**From:** Simon Davis  
**Sent:** 10 November 2025 13:31  
**To:** Planning.Responses  
**Subject:** FW: Land at West Barn, Old Dairy Lane - AL/107/25/PL - SUB PLAN REQUEST  
**Attachments:** 25-01-04 Block and Location Plan Rev D.pdf; 25-01-03 Site Plan Rev D.pdf

**From:** Kate Chapman <[REDACTED]>  
**Sent:** 10 November 2025 13:24  
**To:** Simon Davis <[Simon.Davis@arun.gov.uk](mailto:Simon.Davis@arun.gov.uk)>  
**Subject:** RE: Land at West Barn, Old Dairy Lane - AL/107/25/PL

**From:** Simon Davis <[Simon.Davis@arun.gov.uk](mailto:Simon.Davis@arun.gov.uk)>  
**Sent:** 06 November 2025 09:42  
**To:** Kate Chapman <[REDACTED]>  
**Subject:** RE: Land at West Barn, Old Dairy Lane - AL/107/25/PL

CLIENT BioDot		
PROJECT New office building adjacent to West Barn Norton Lane, Norton, Aldingbourne		
DRAWING TITLE Block Plan and Location Plan		
DATE Feb 2025	SCALE As shown	DRAWN BY
		CHECKED BY
JOB NO. 25 / 01	DRAWING NO. 04	REVISION Rev C

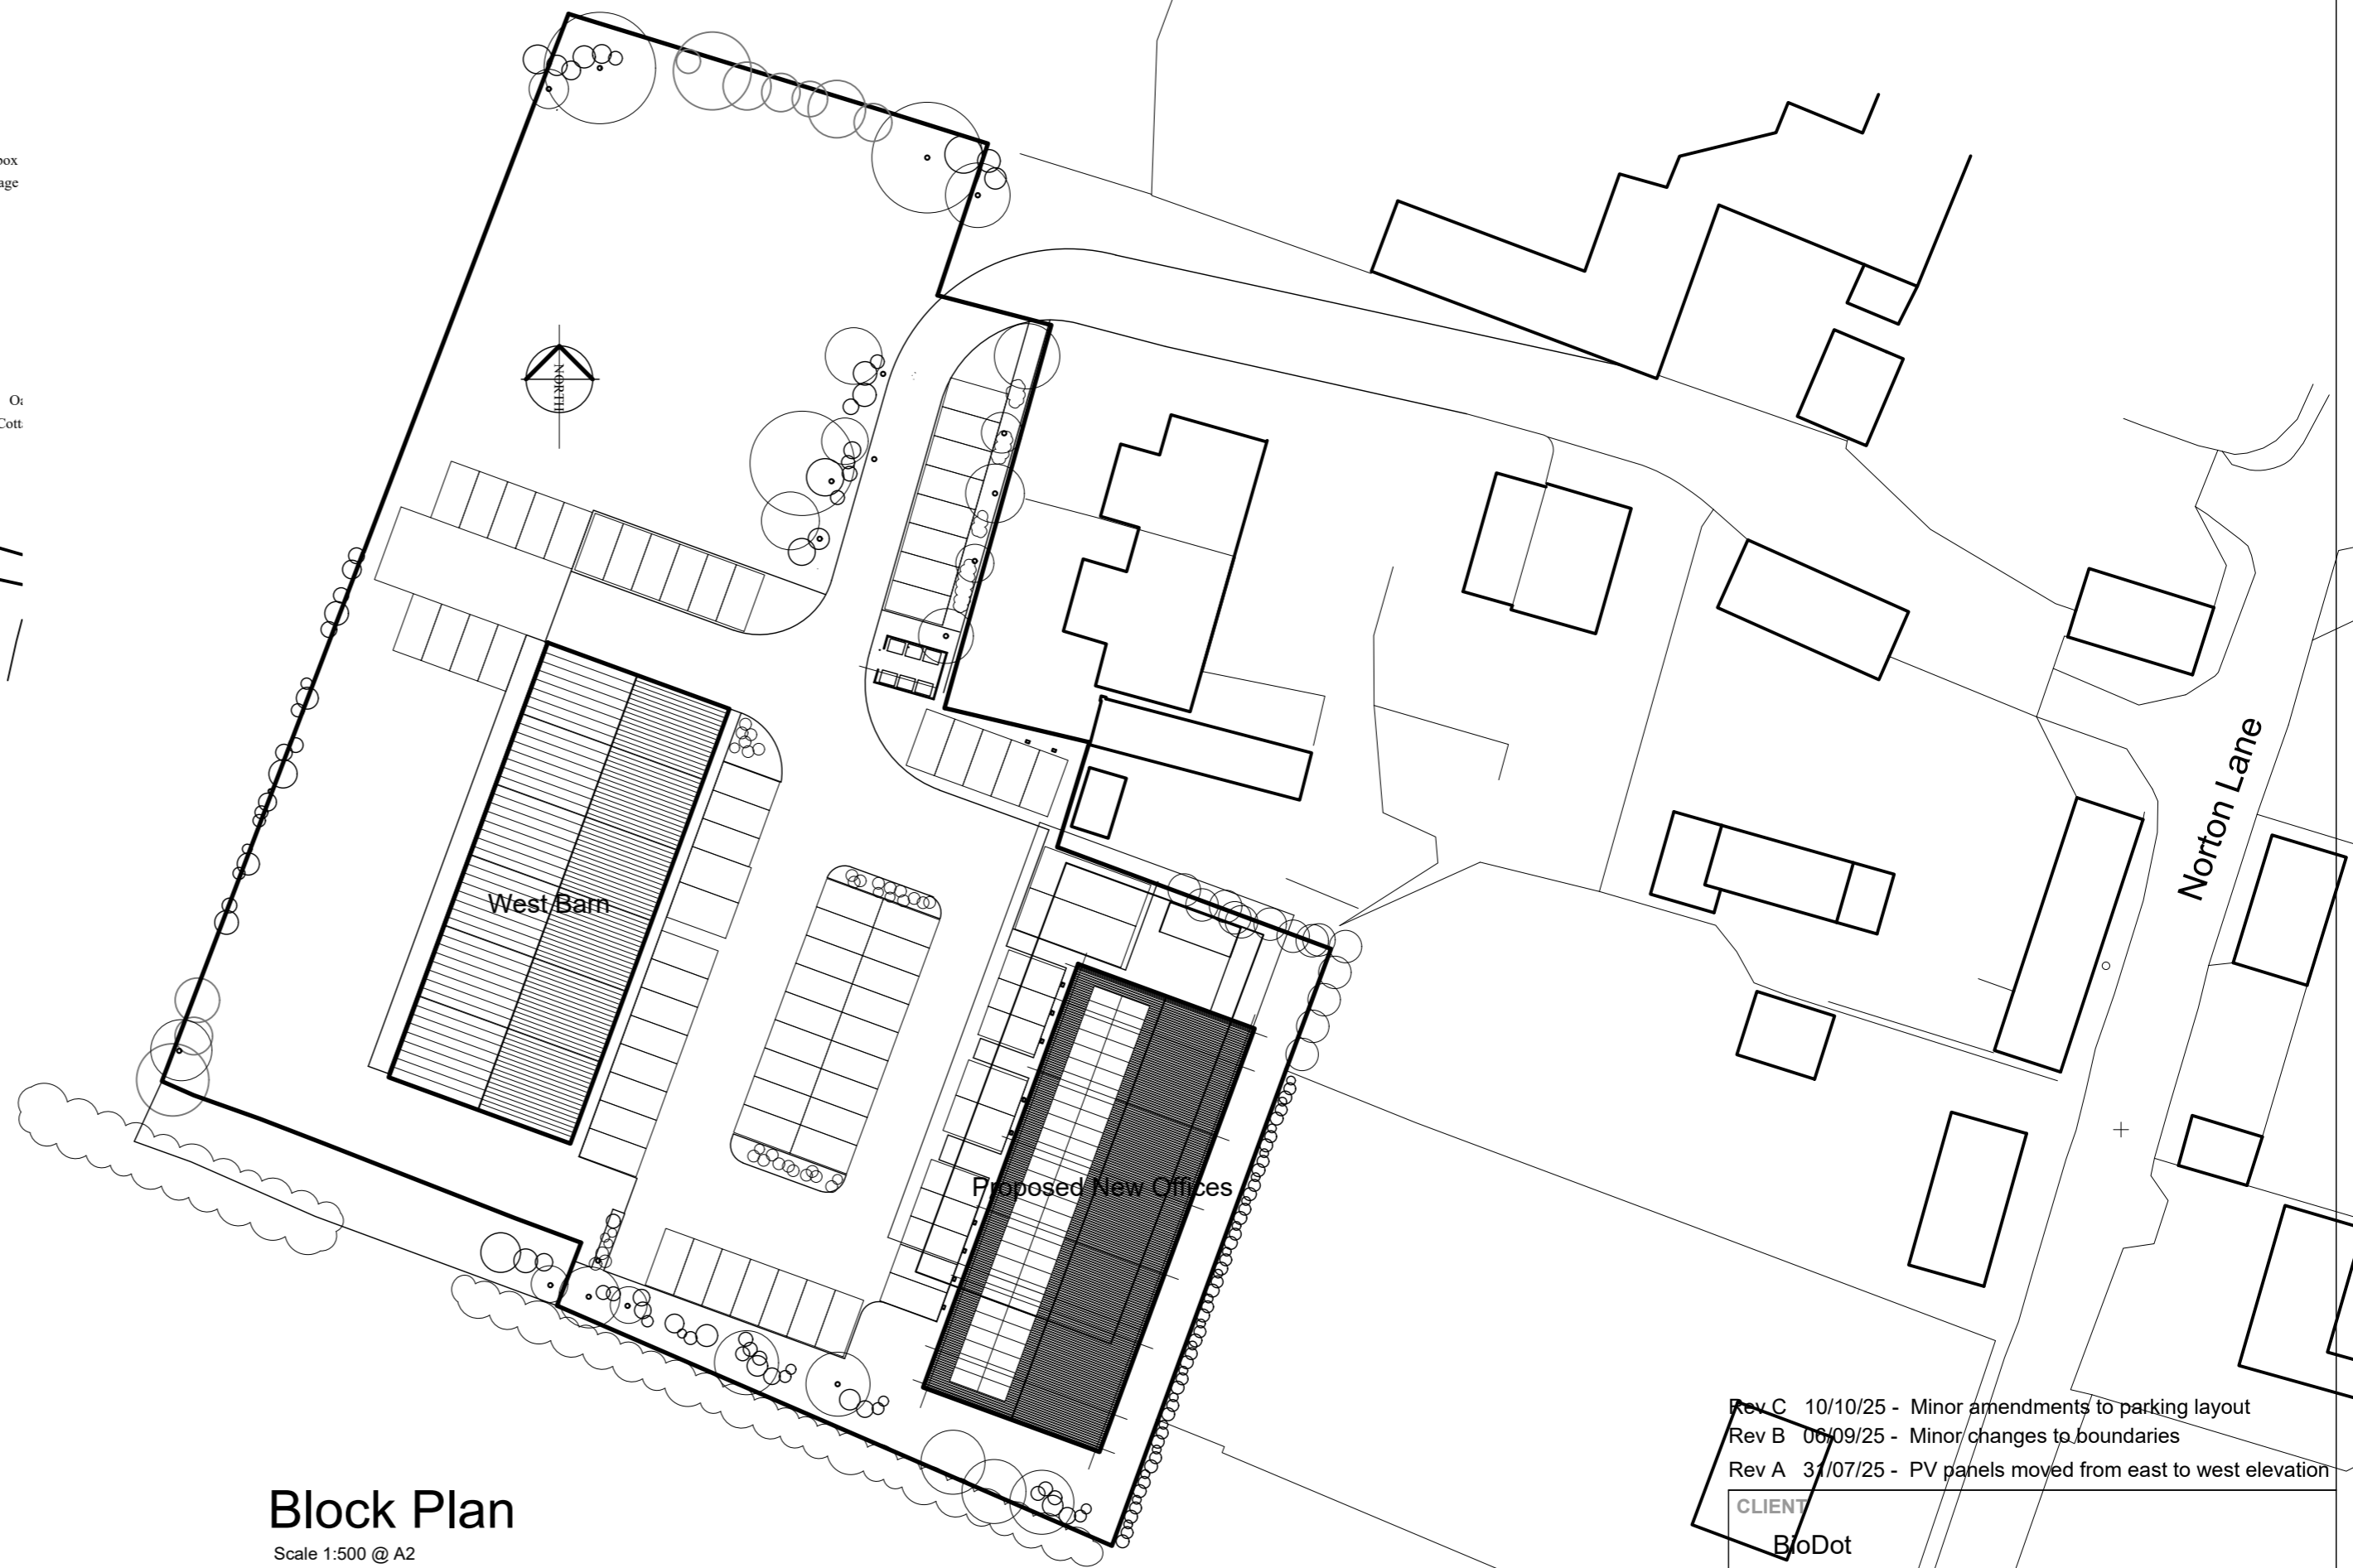
A resident has written to state that the plans are inaccurate as not all nearby buildings are shown. Whilst this was not a validation requirement, I can see that there are differences between our OS mapping and your location and block plan including that a dwelling immediately adj the northern boundary (The Old Stables) is not shown. Also, other dwellings are not drawn to their correct shape. This may affect the assessment of impact on other buildings. I would therefore request that you provide an updated version of the plans please.

Block and Location Plan Dwg No. 04 Rev D  
Site Plan Dwg No. 03 Rev D
